Re: Proposed Development at Bicester Gateway: LLFA Response

Further to the correspondence you received from Oxfordshire County Council regarding the Flood Risk and Drainage report that we prepared in support of the planning application reference 20/00293, we have updated the report to Revision D, as attached, and we summarise our response below.

**FLOOD RISK AND
DRAINAGE ASSESSMENT
FOR A PROPOSED
COMMERCIAL
DEVELOPMENT ON LAND
TO THE WEST OF
WENDLEBURY ROAD,
BICESTER, OXFORDSHIRE**

**PROJECT NO.
JAG/AD/JP/43386-Rp001D**

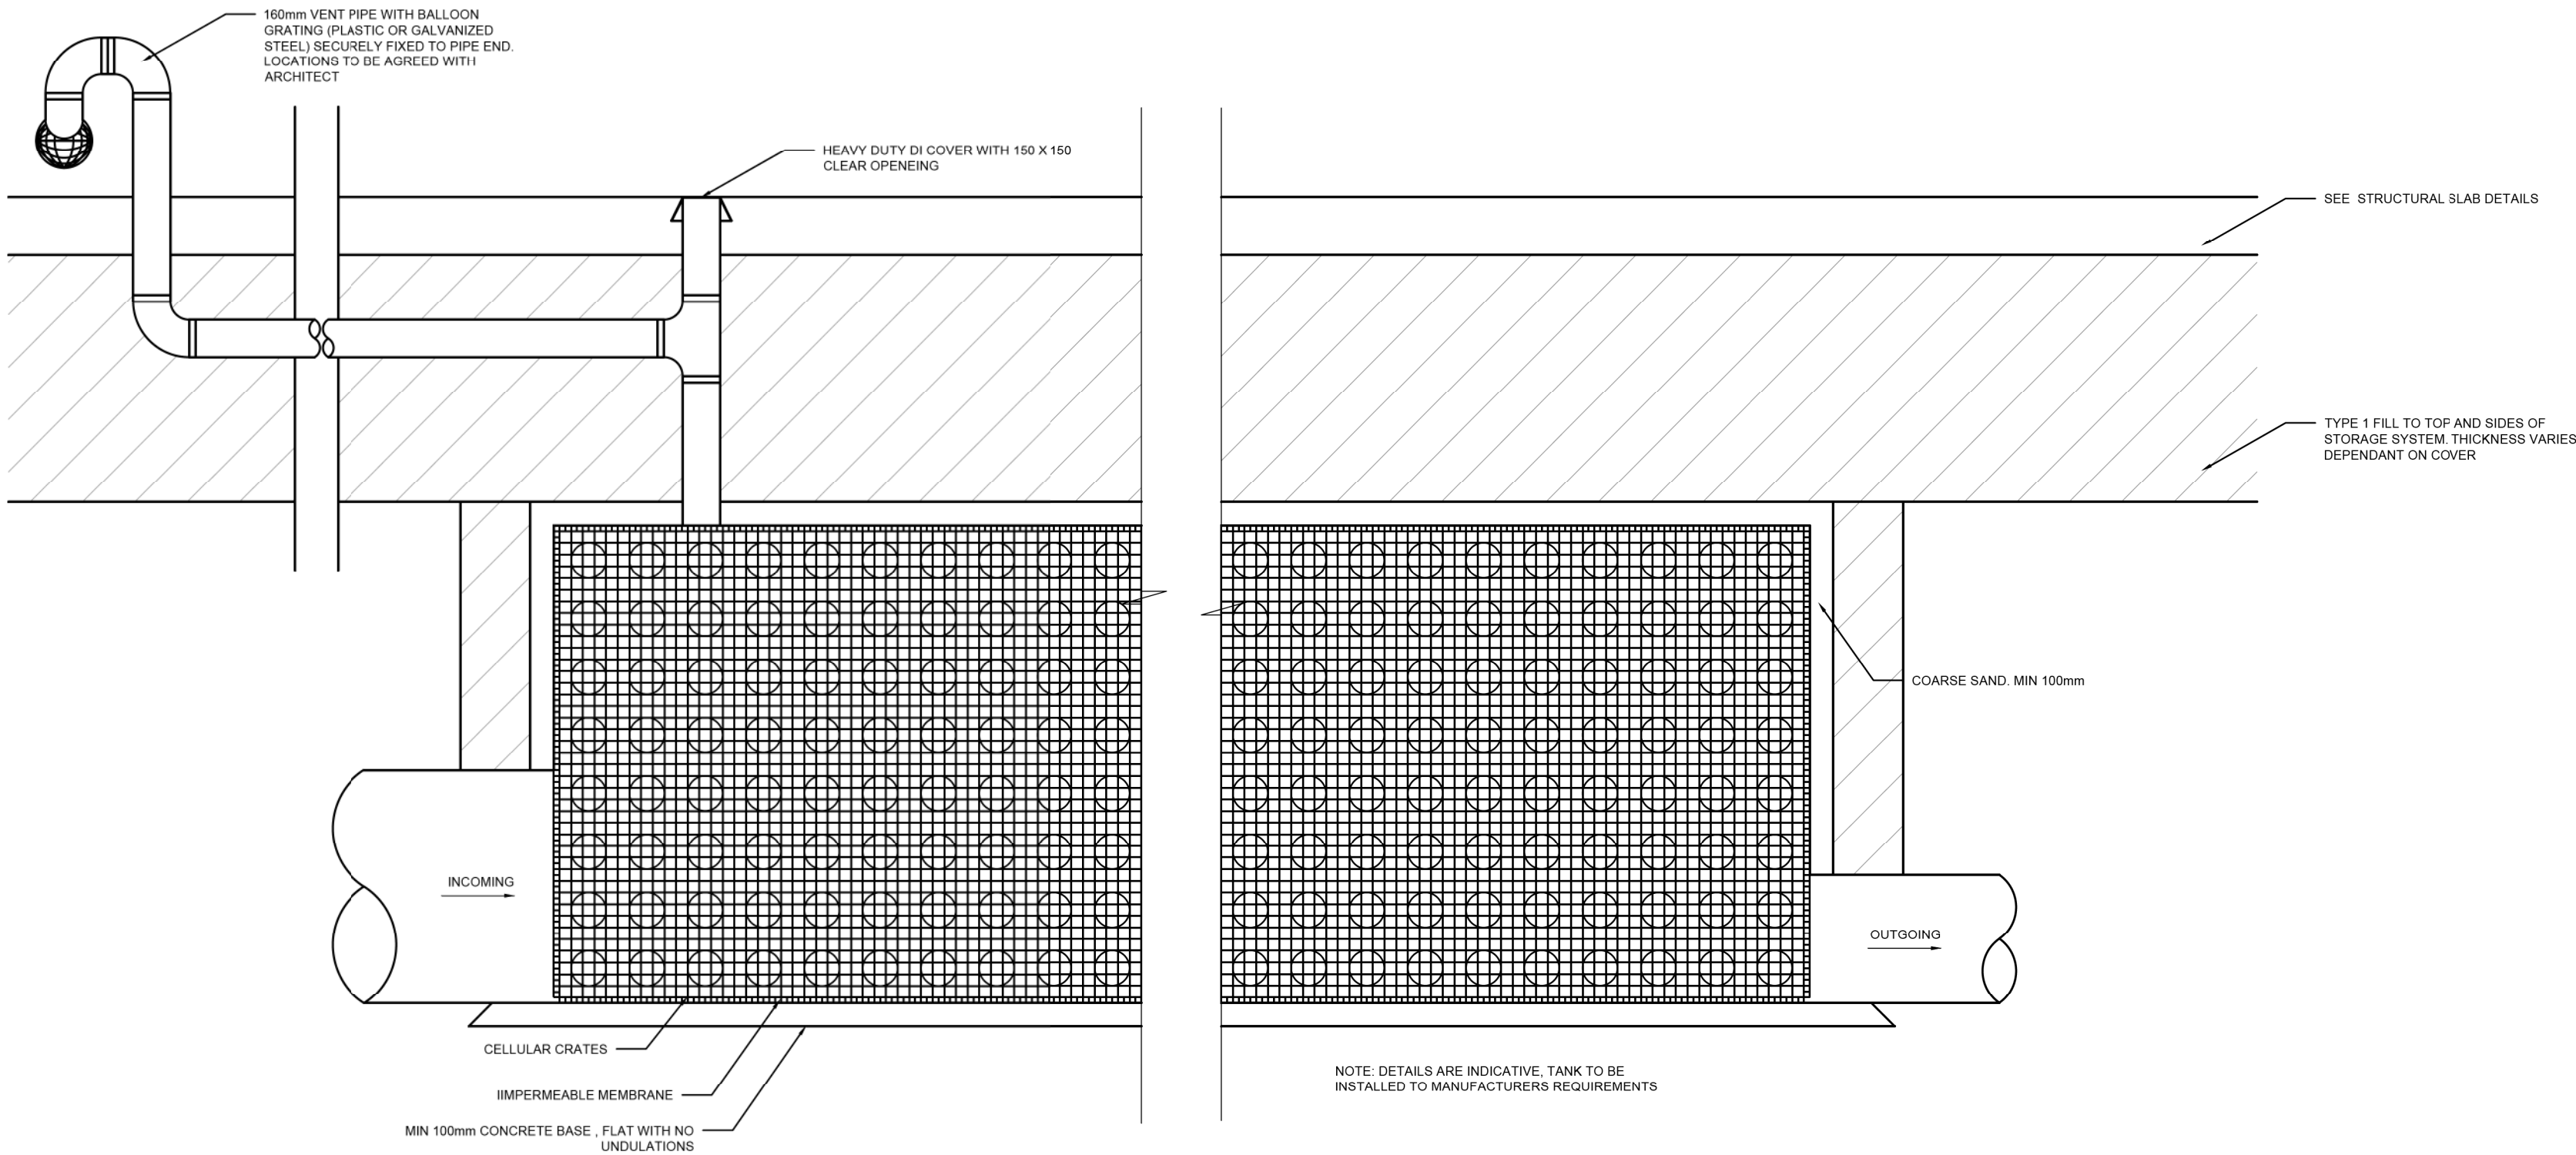
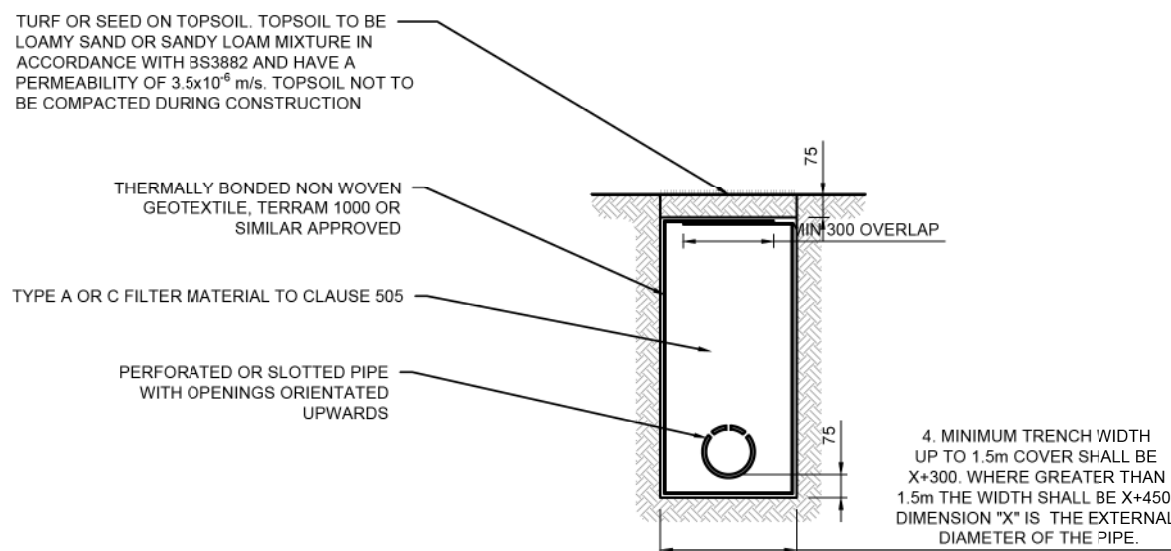
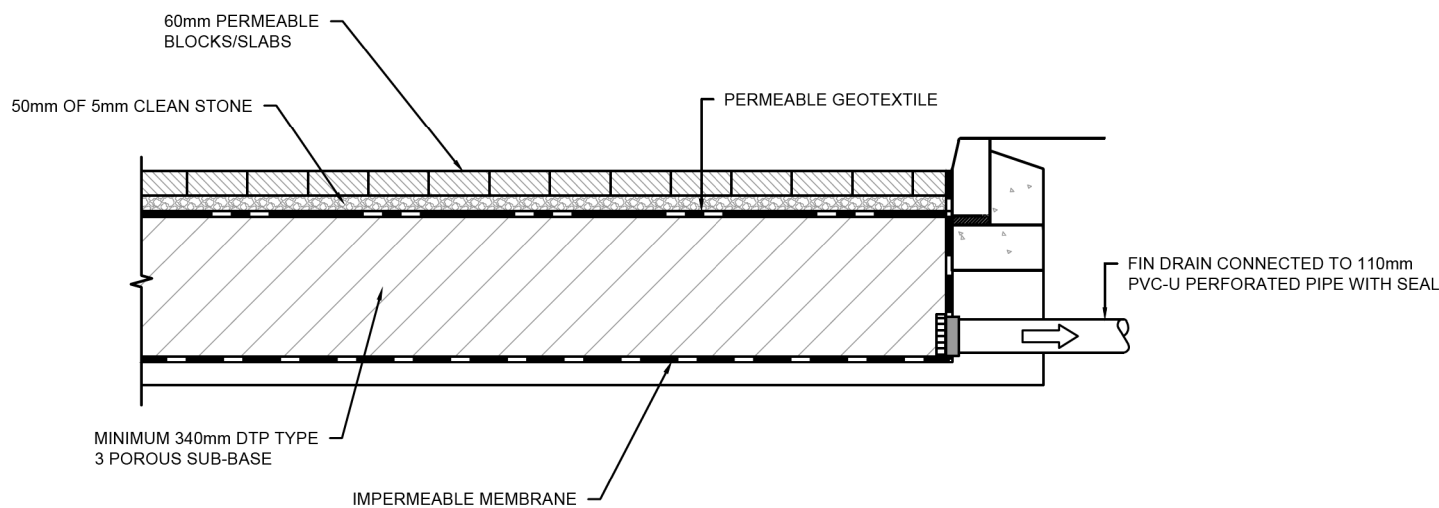
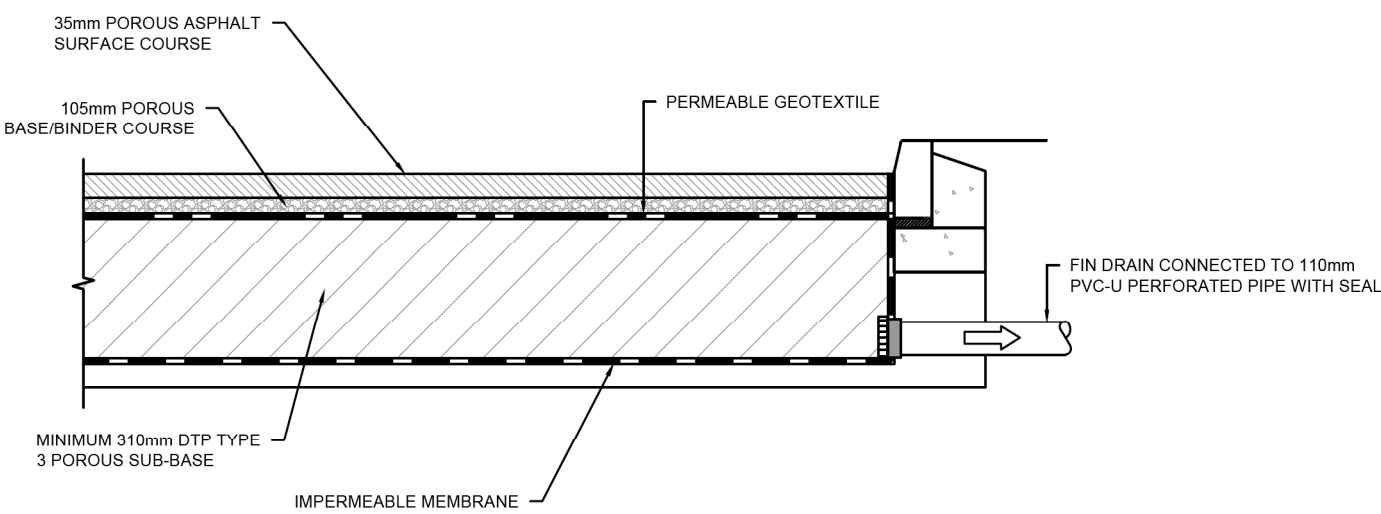
We have provided cross-section drawings of the SuDS and the pumping station in the updated report.
